KITTITAS COUNTY

MEMORANDUM

TO: All Staff
FROM: Public Works Plan Review Team
DATE: September 20, 2024
SUBJECT: BL-24-00019 Moore

RECORD OF SURVEY

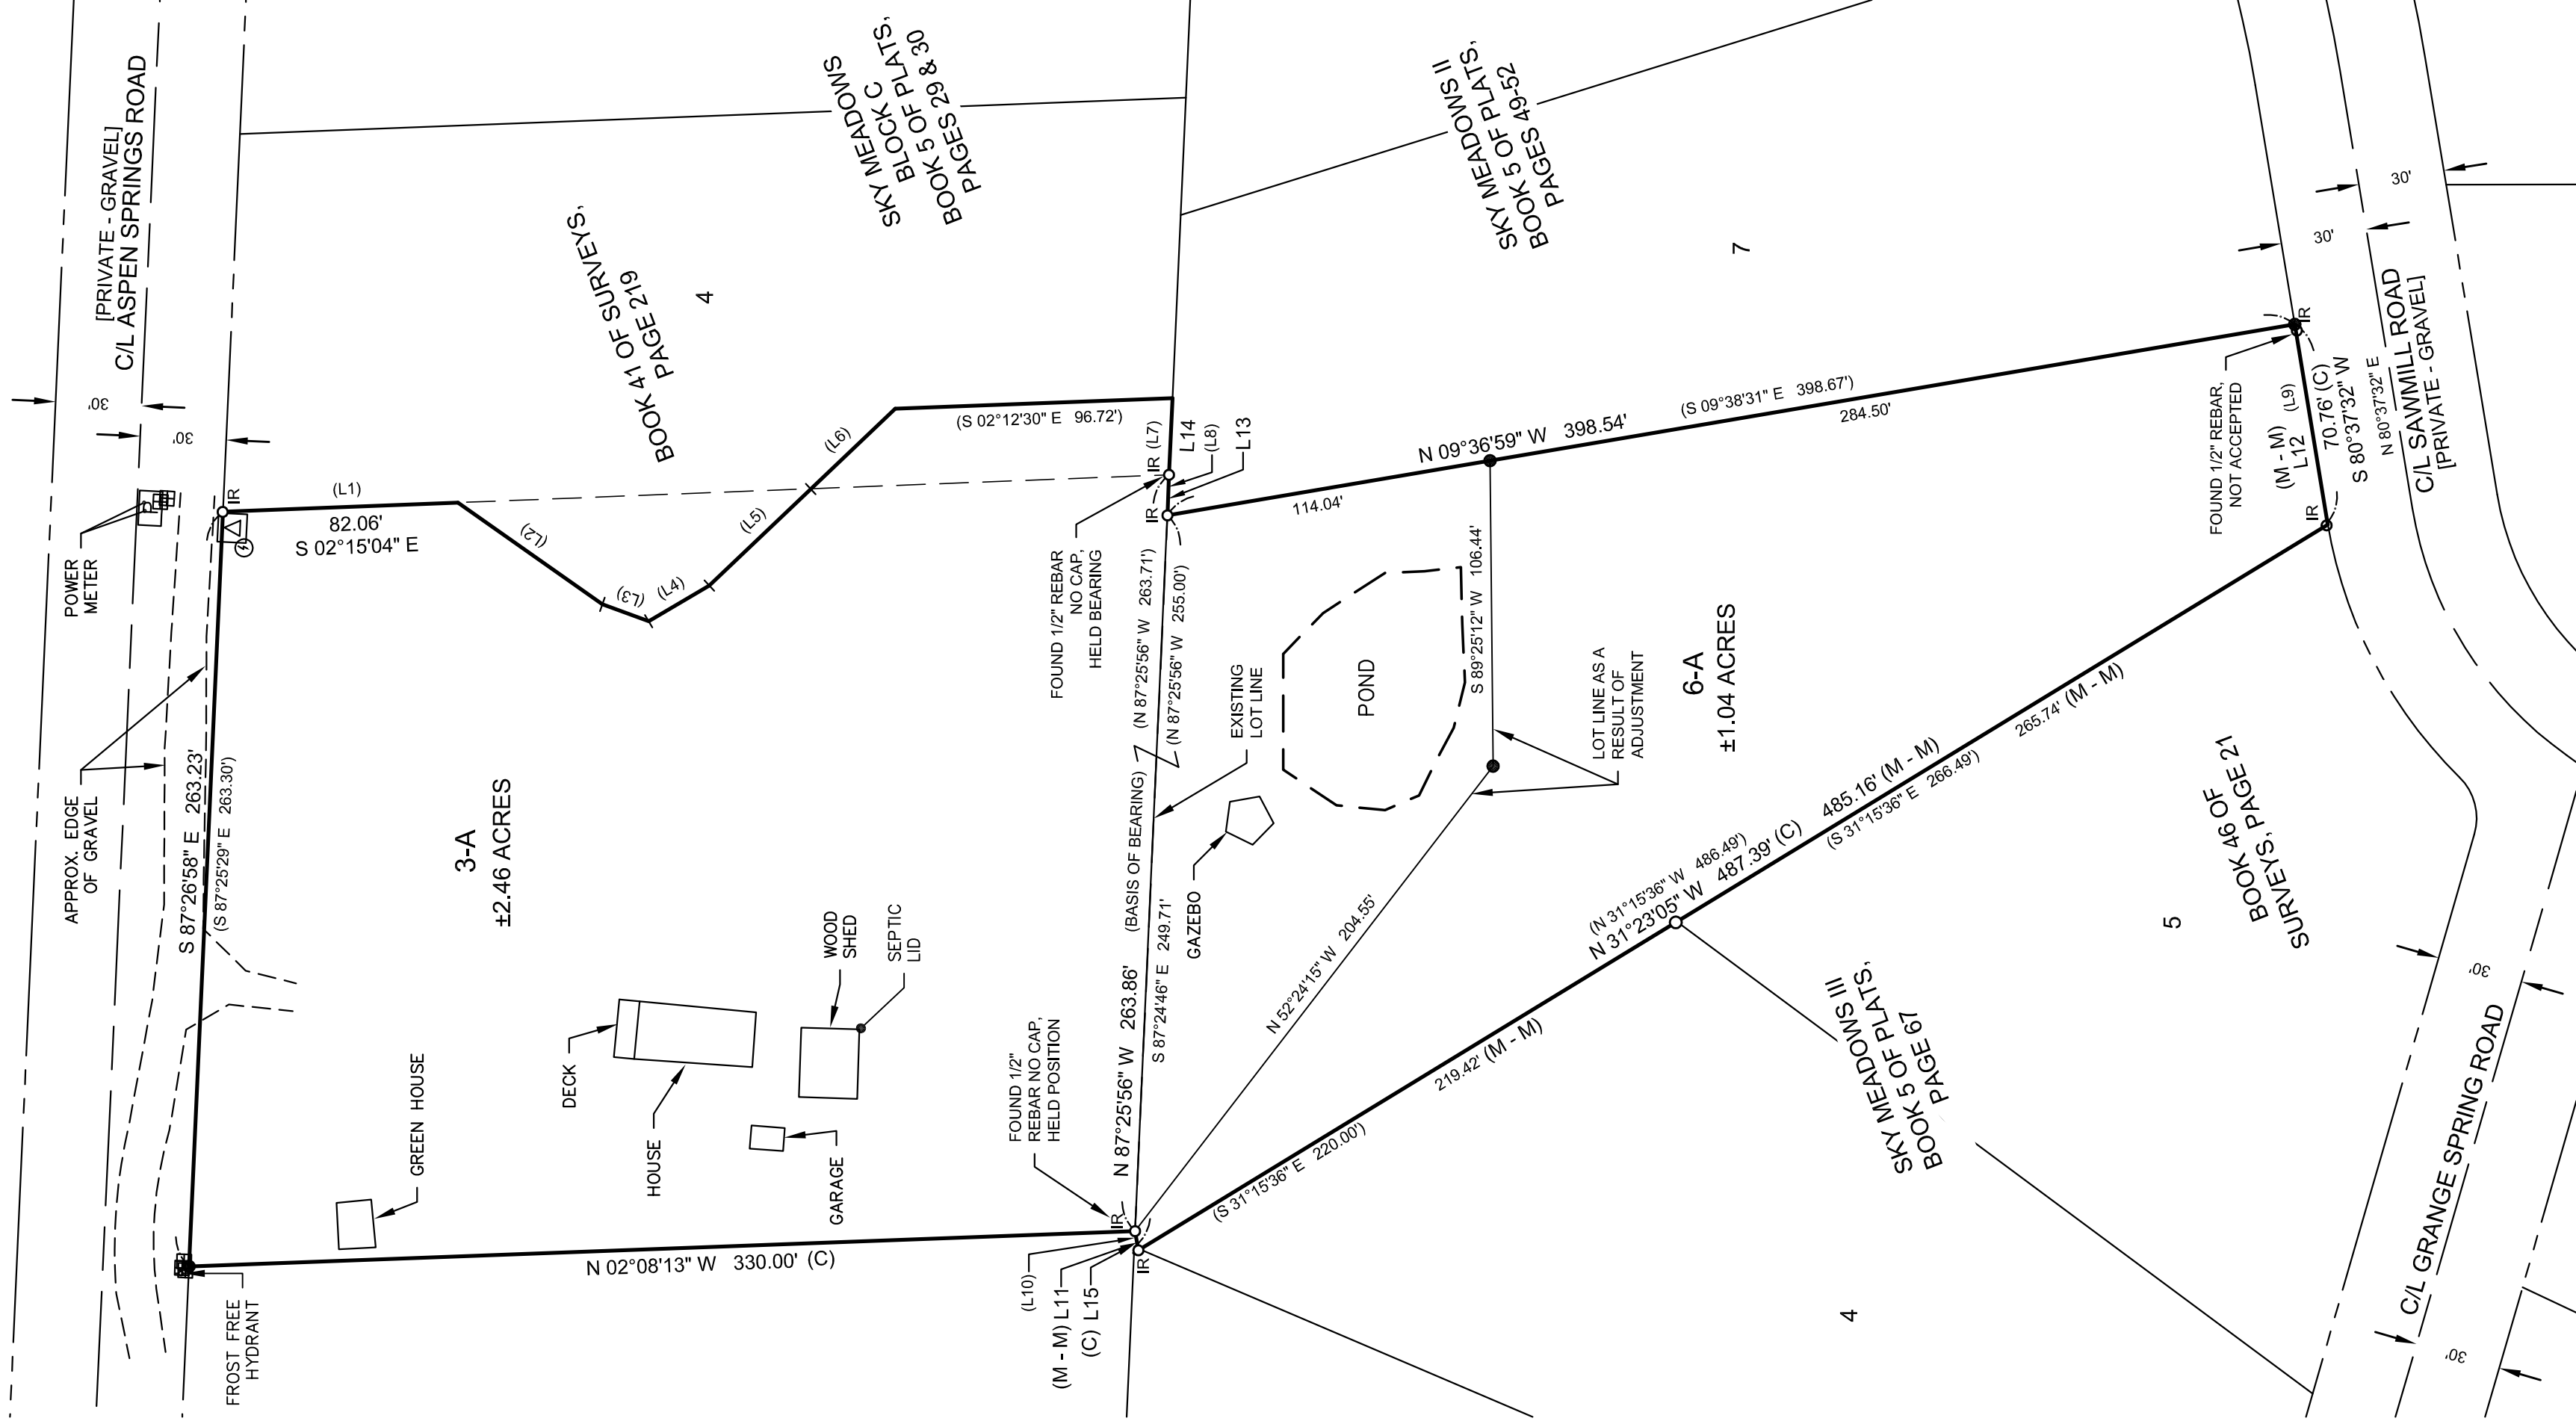
SURVEY	<p>Comments reserved until final survey (KH)</p> <p>UPDATE 10/01/2024</p> <ol style="list-style-type: none">1. The bearing and descriptions for all boundaries should be re-reviewed by the applicant. There are multiple issues including: adding up distances that do not match total line length, unclear relationships between calculated, measured and record, and record distances not being in brackets. Please make it clear for sensible retracement of the survey. Also ensure that final boundaries as shown clearly match with the lot closure report. Some record bearings and distances do not match the legal description. This may be an error, or may be referencing a different record. If it is a matter of different record, the record documents referred to shall be clearly noted.2. All roads should include ownership and surfacing.3. New legal descriptions appear to be a mix of record info and measured info.4. Detail purpose of 2 lines shown along West line of Lot 6-A. (JT)

<p>UPDATE 11/14/2024</p> <p>The submittal has addressed all prior survey comments.</p> <p>OF NOTE</p> <p>Showing the Bearings and distances to be utilized for future retracement could be addressed by text styles. While the inclusion of all line values is a benefit, it currently makes retracement burdensome. (JT)</p>
TRANSPORTATION CONCURRENCY	No transportation concurrency requirement for this project. (KAH)
FLOOD	No comments. (SC)
WATER MITIGATION/ METERING	No comments. (SC)
AIRPORT	No comments. (JS)
